Response to Local Highway Authority Comments

Land East of Claydon Road – Proposed Development

Application No. 23/00977/OUT

Title :  
**Proposed Site Access & Visibility Splays**

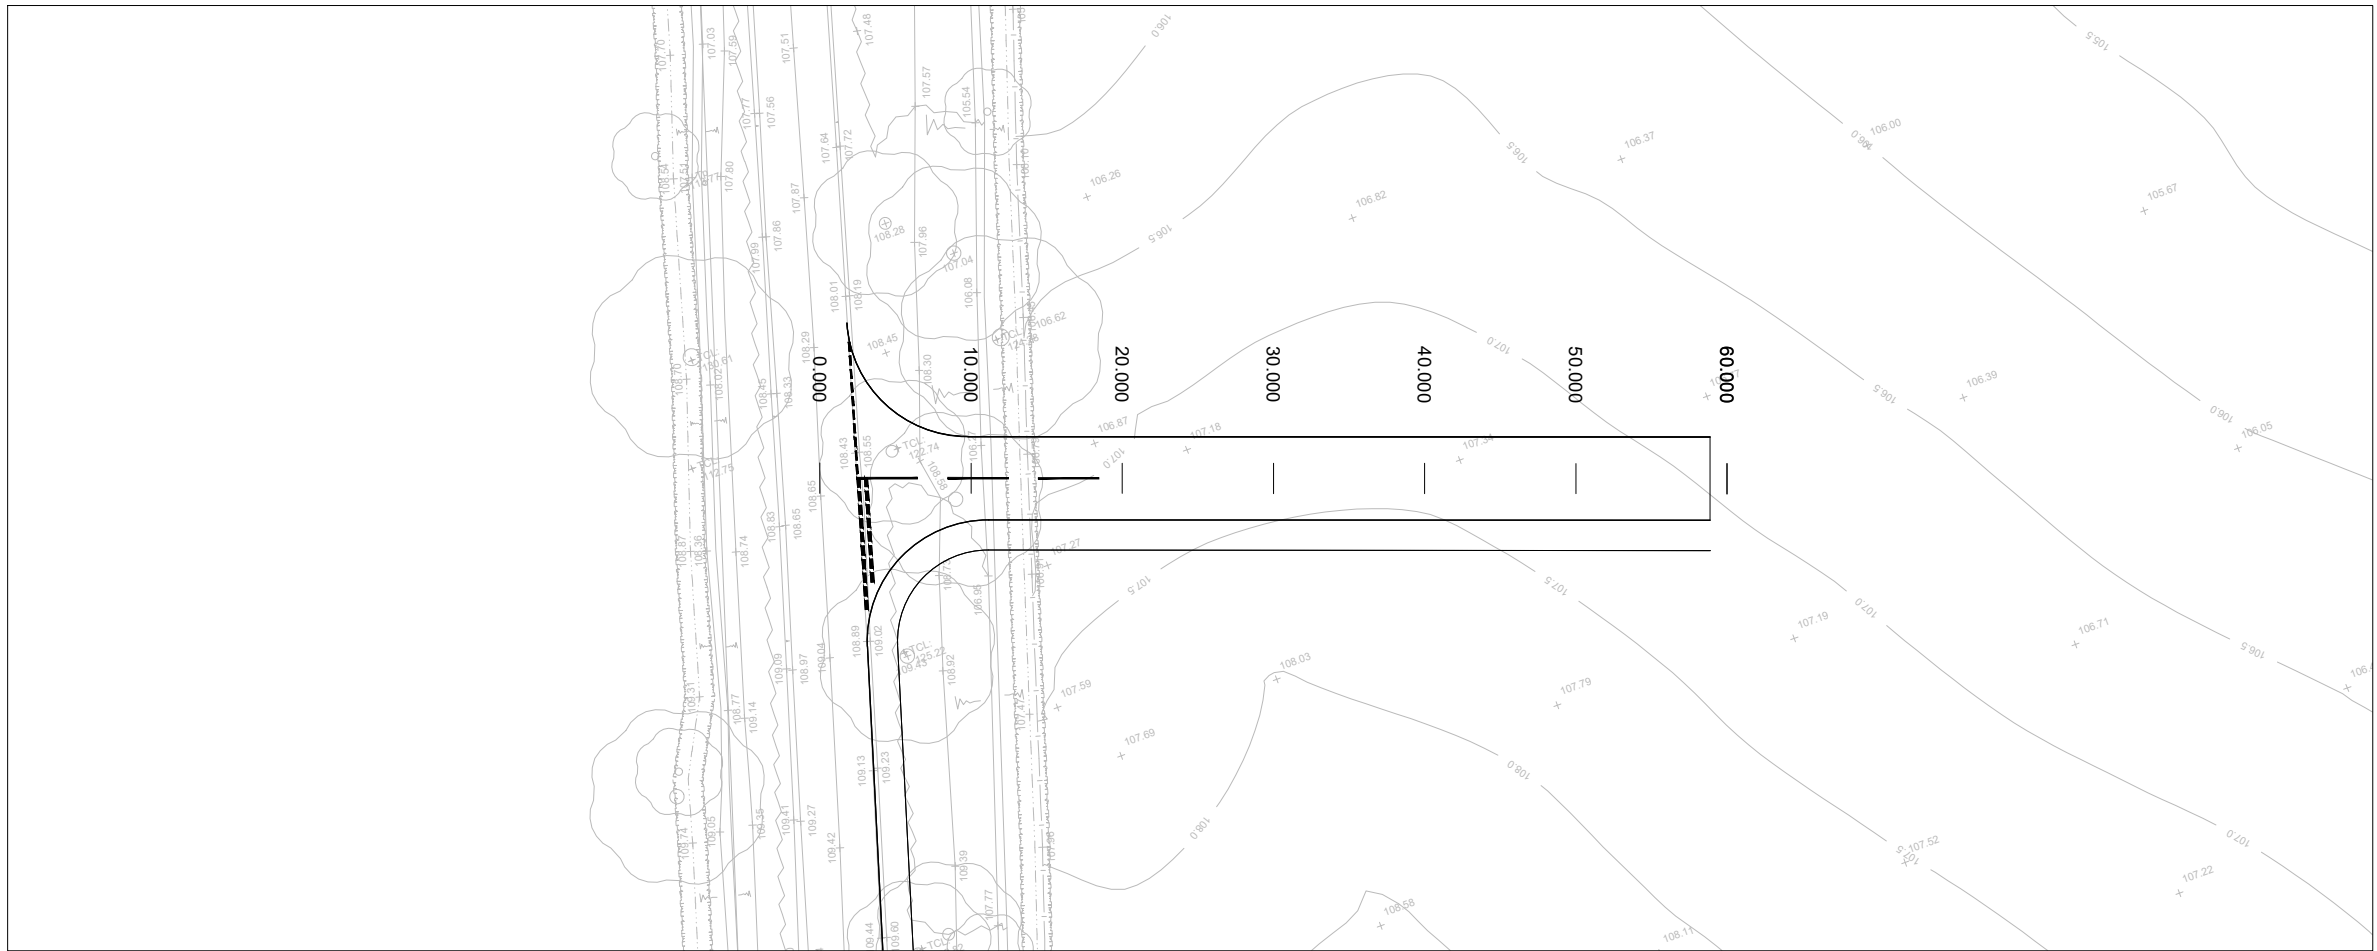
- 3.1 Although some site access dimensions were shown on the access arrangement drawing 8210439/6101_C, additional dimensions have been shown on updated drawing 8210439/6101_D at Appendix B to close out Point 2a of the LHA's response.

Title :  
**Site Access  
Swept Path Analysis  
11.6m Refuse Vehicle**

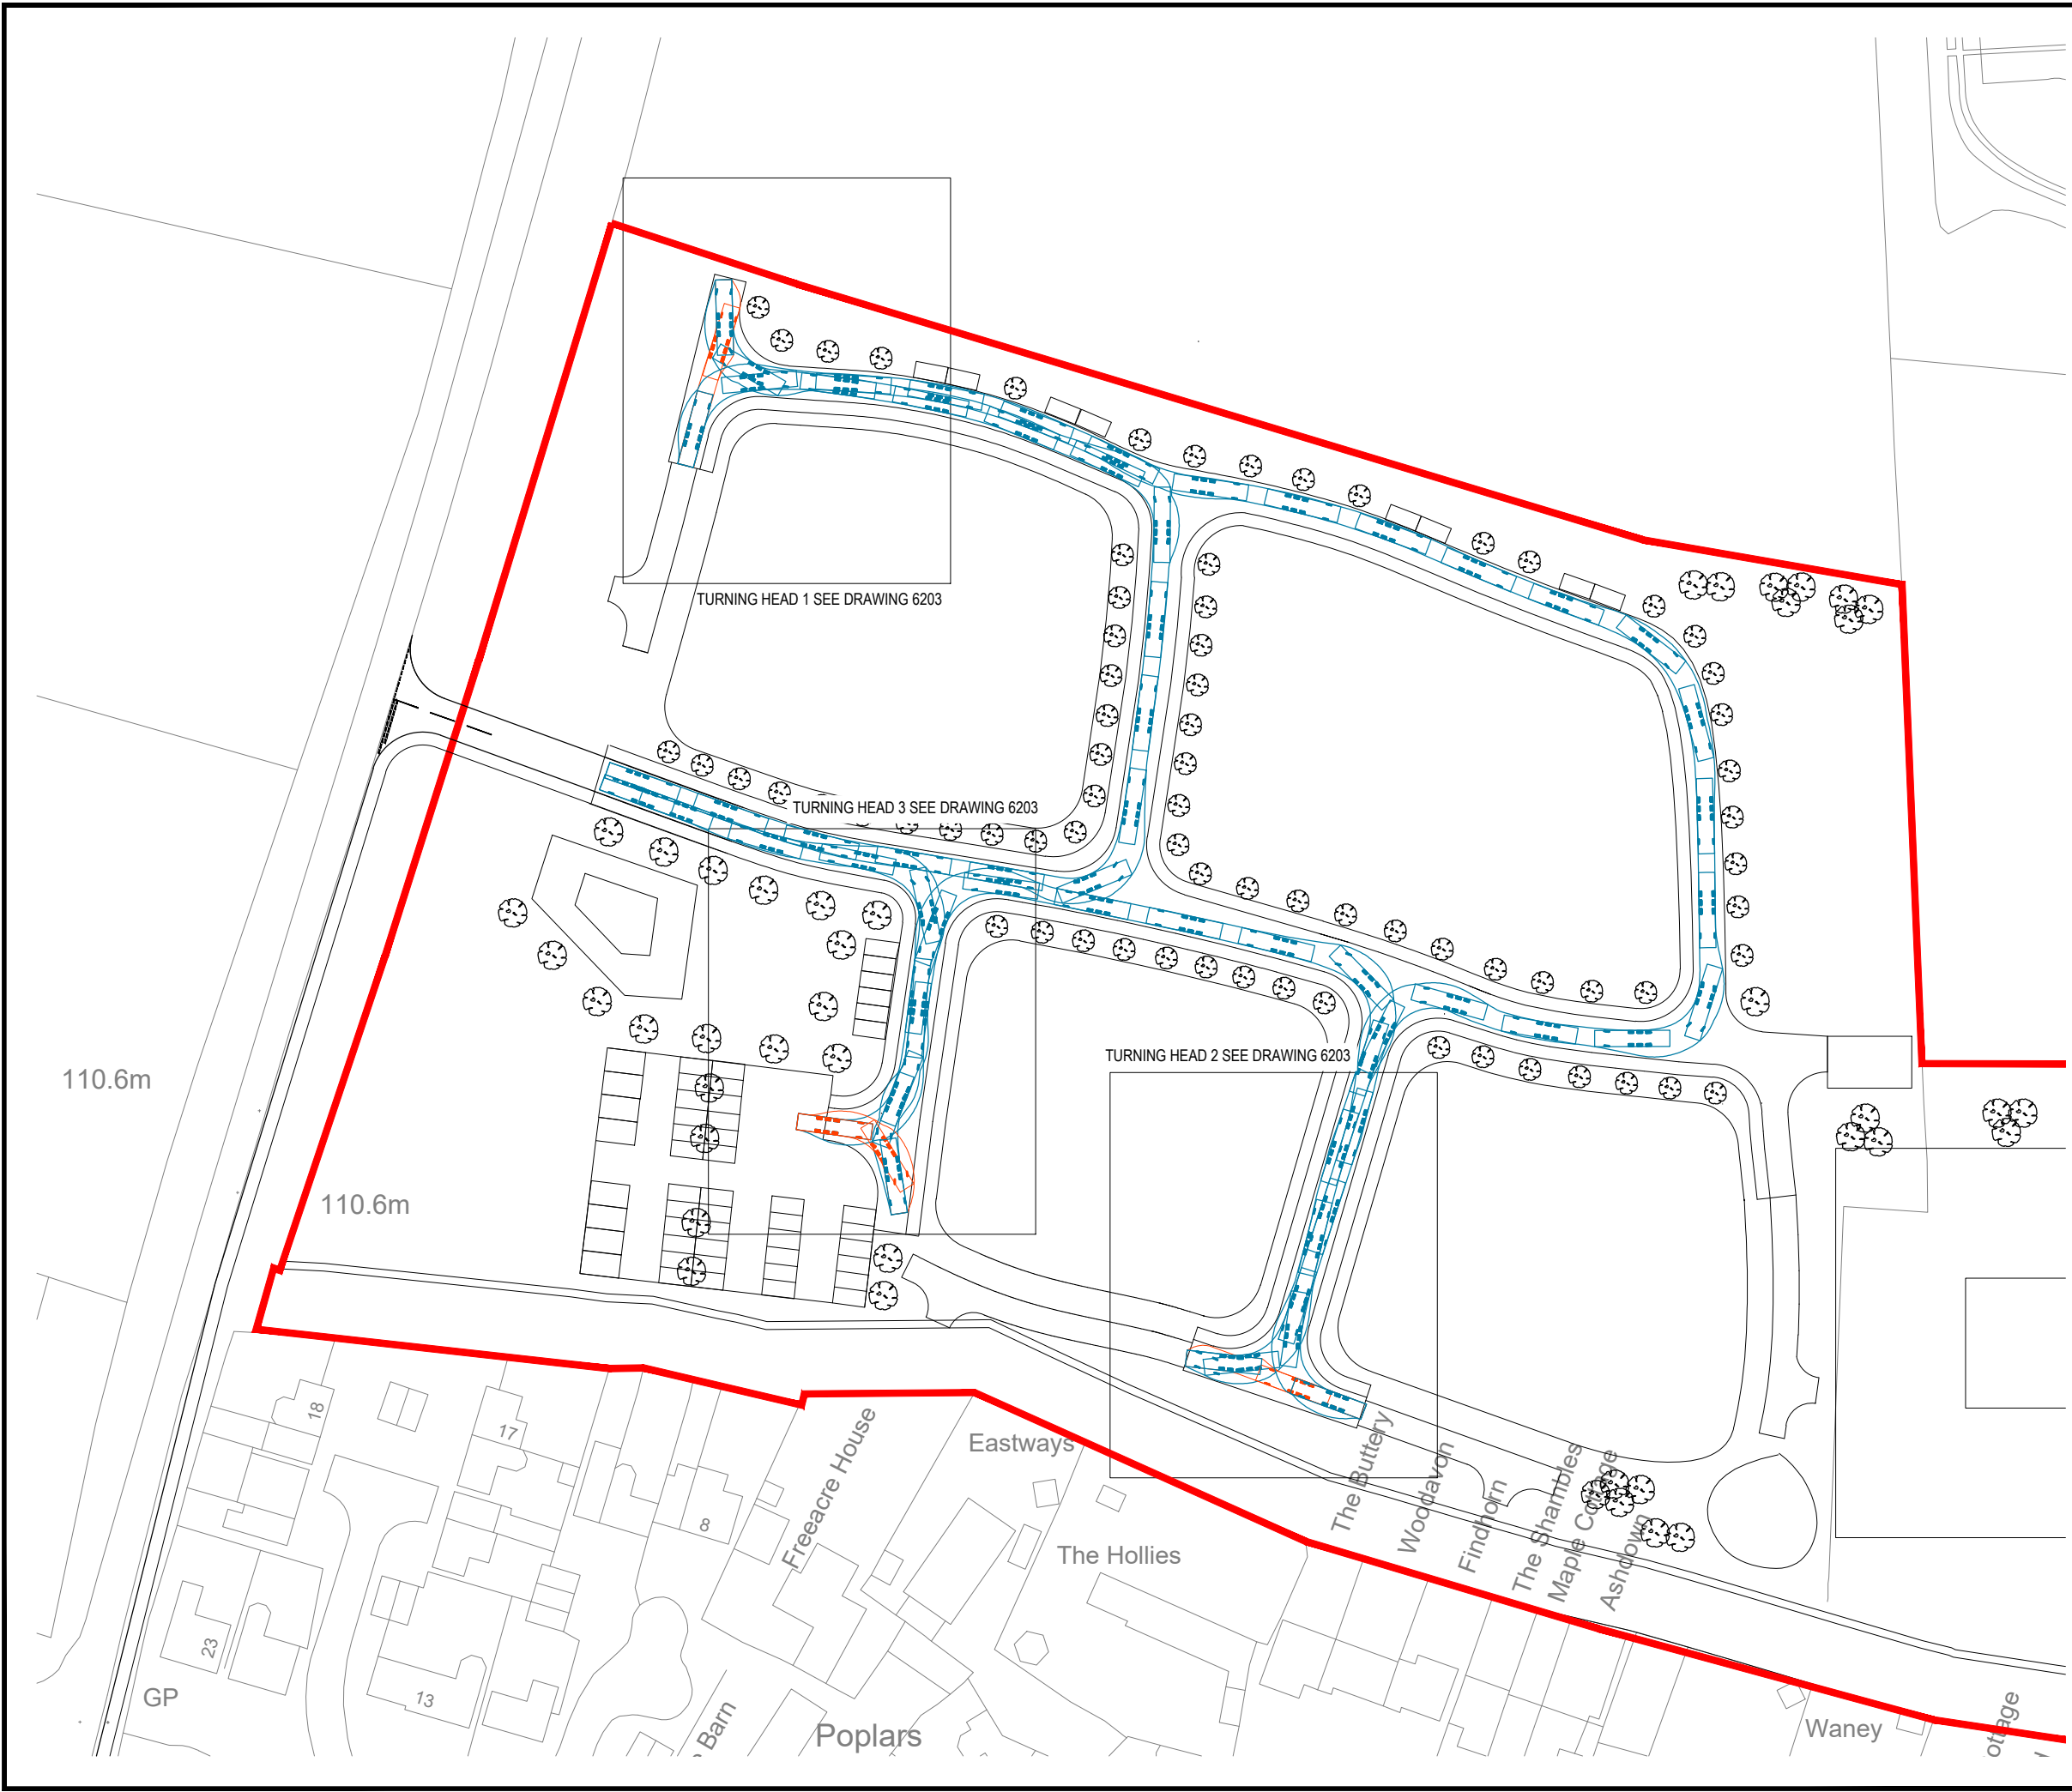
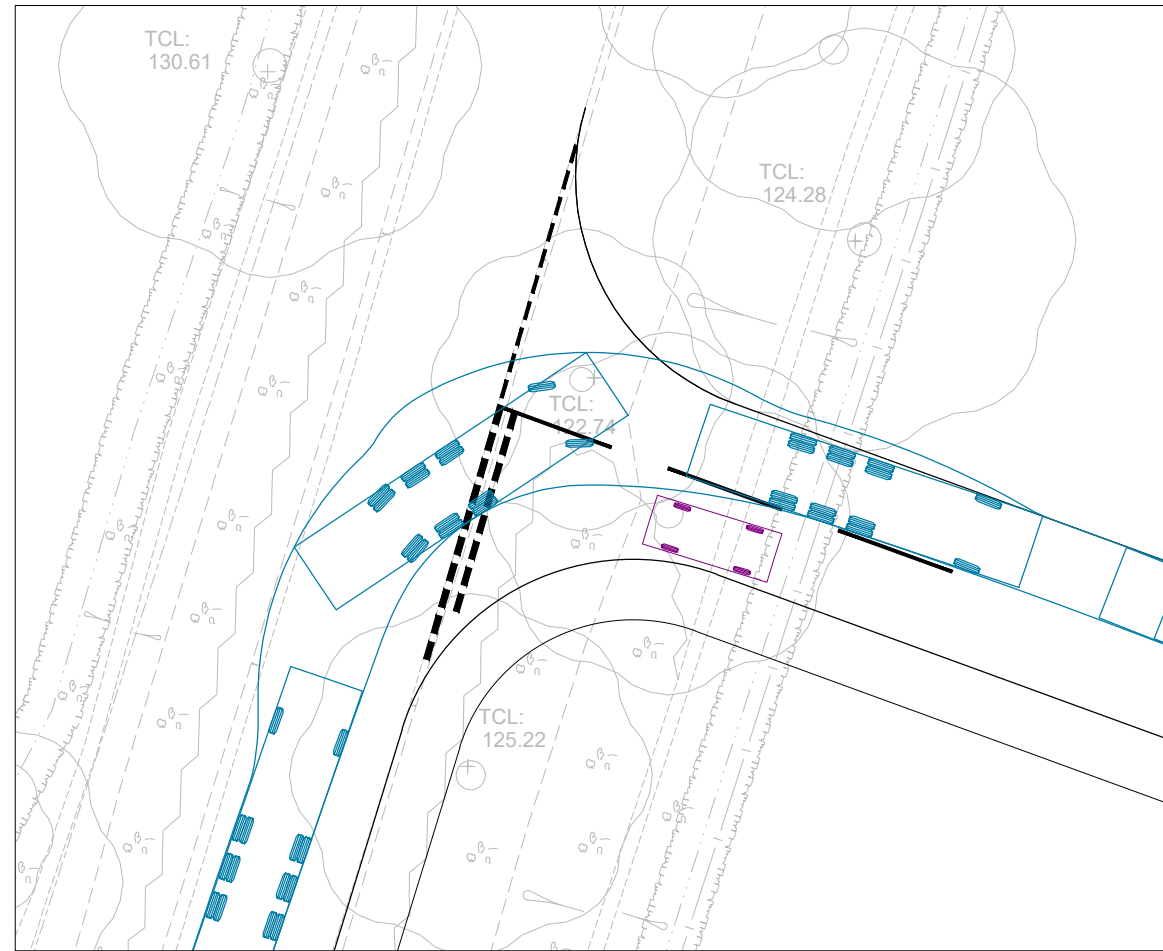
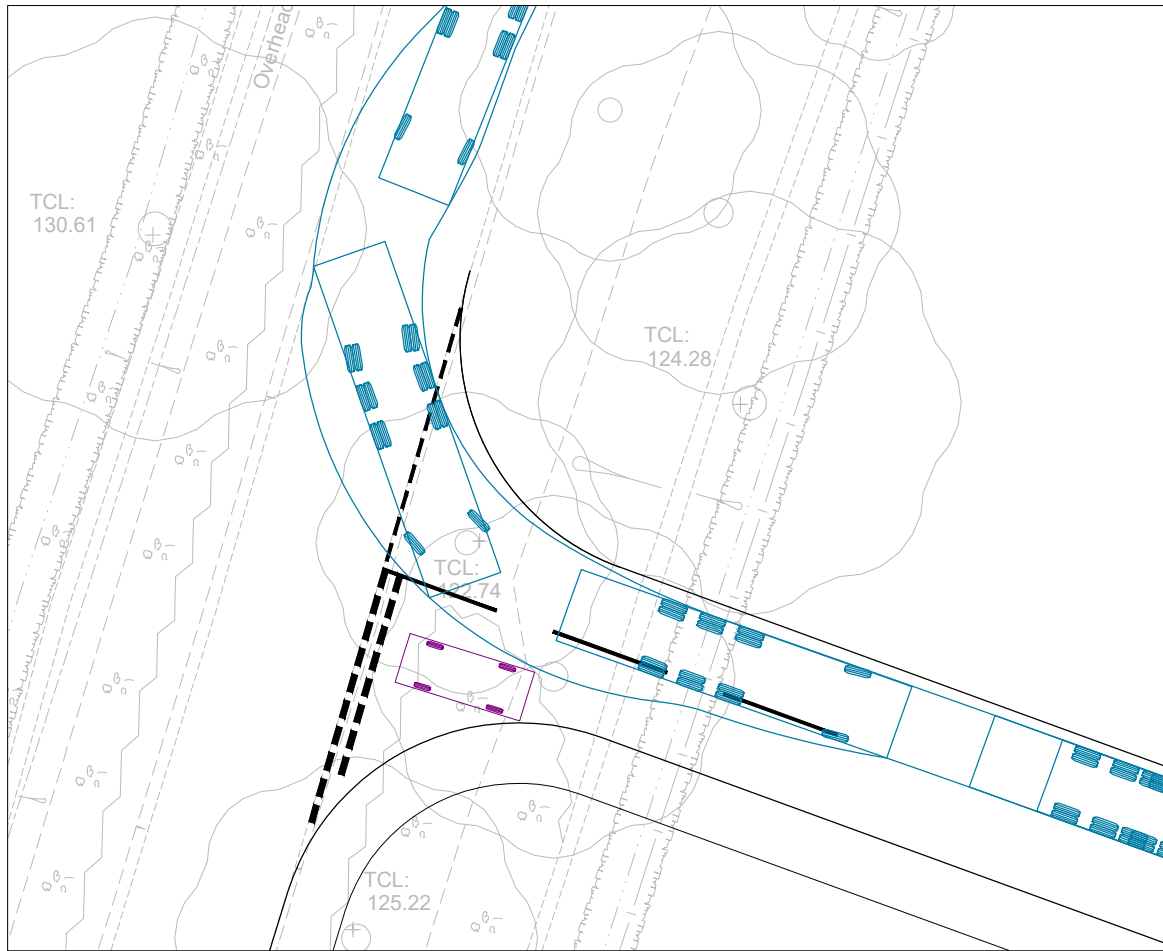
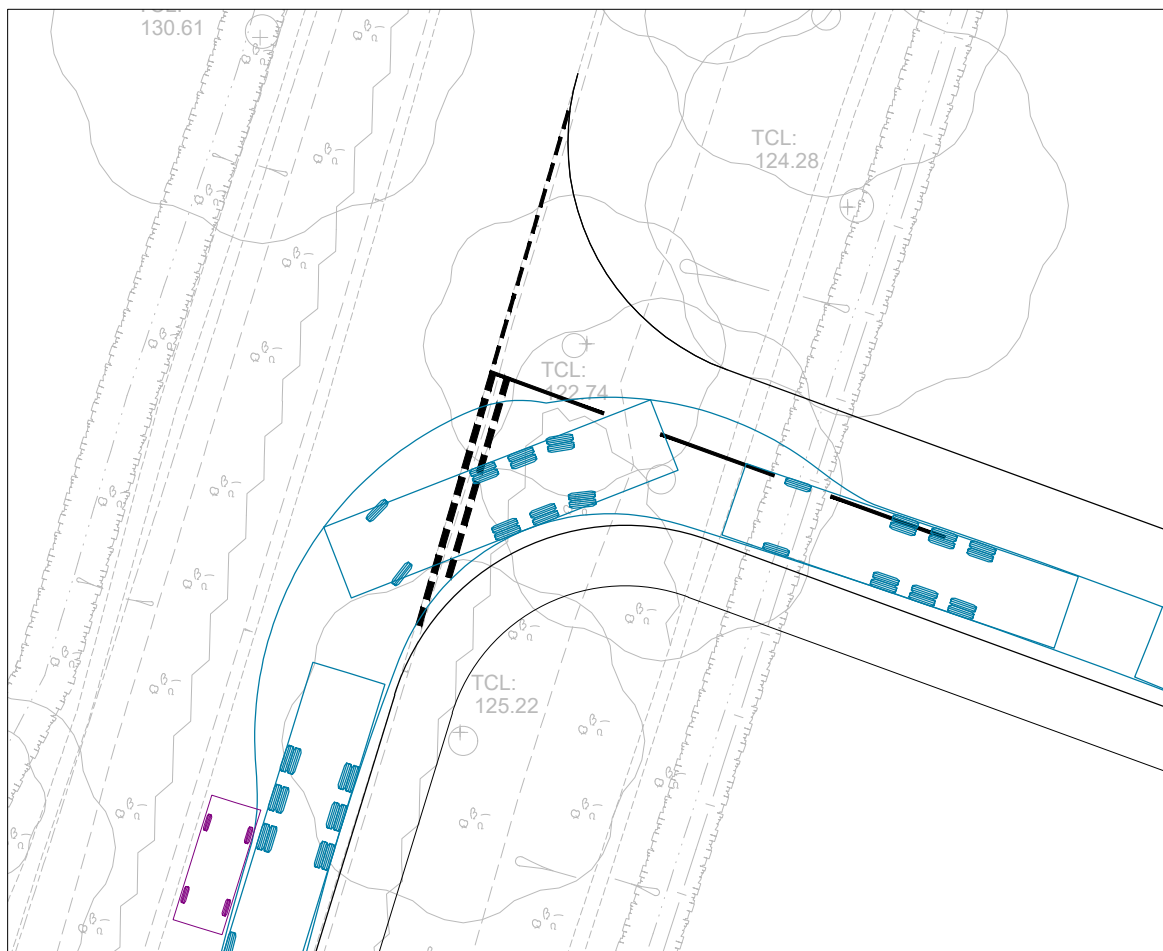
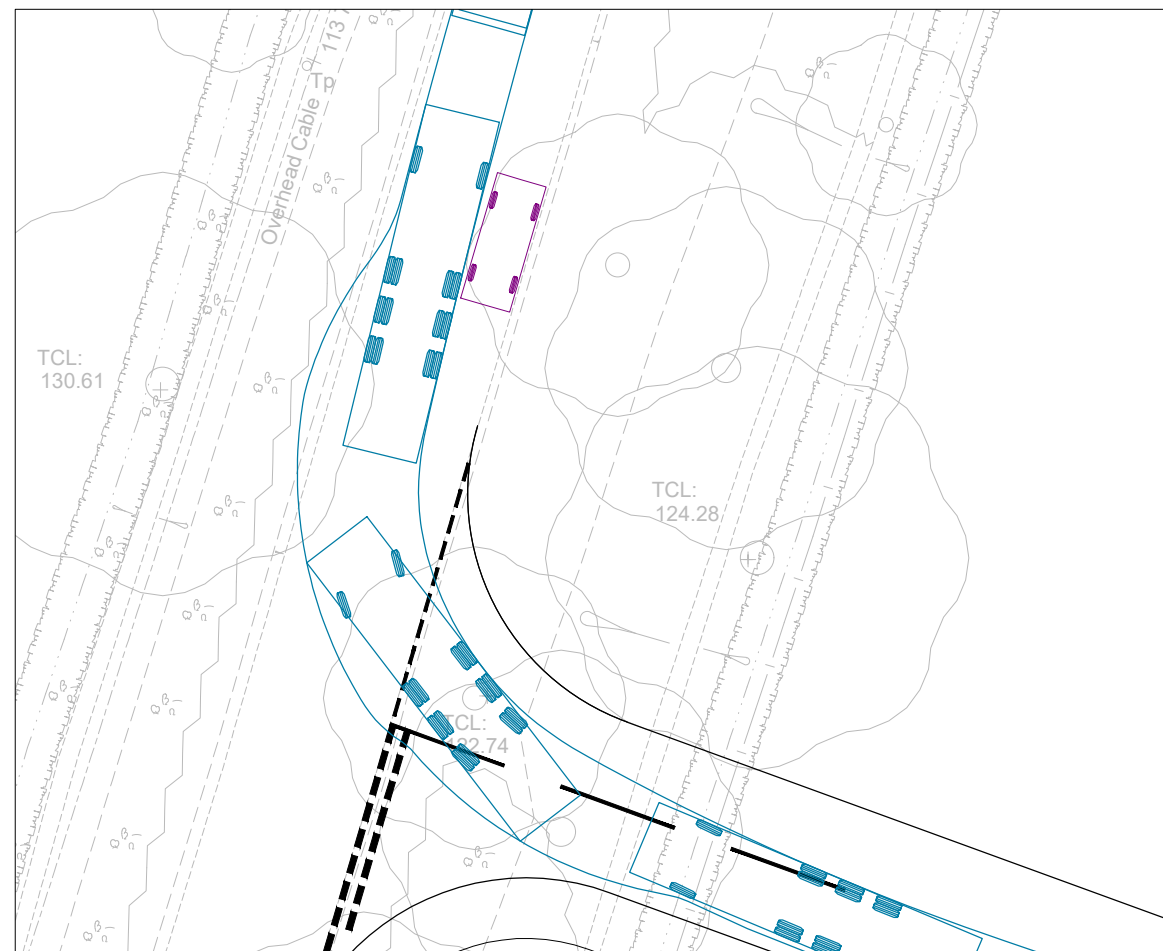
- 3.2 In its consultation response, the LHA stated that *"Vehicle tracking at the access largely covers opposite lanes on all movement which could cause collisions, this should be addressed by the Applicant"*.

- 3.3 Paragraph 6.8.1 of Manual for Streets states that *"The design of local roads should accommodate service vehicles without allowing their requirements to dominate the layout. On streets with low traffic flows and speeds, it may be assumed that they will be able to use the full width of the carriageway to manoeuvre"*.

- 3.4 As outlined in the Transport Statement, Claydon Road is very lightly trafficked, with a weekday (5-day) average of 439 vehicles travelling northbound and 390 travelling southbound. Given refuse collection would be a once per week occurrence, the likelihood of a car travelling along Claydon Road at the same time as a refuse vehicle is considered very low.

- 3.5 Furthermore, the swept path analysis at Appendix C demonstrates that sufficient space is available for a car and refuse vehicle to pass each other at the site access and on Claydon Road.

- 3.7 Based on the above, it is considered that no alterations are required to the proposed site access arrangement, thereby addressing Point 2d of the LHA's response.
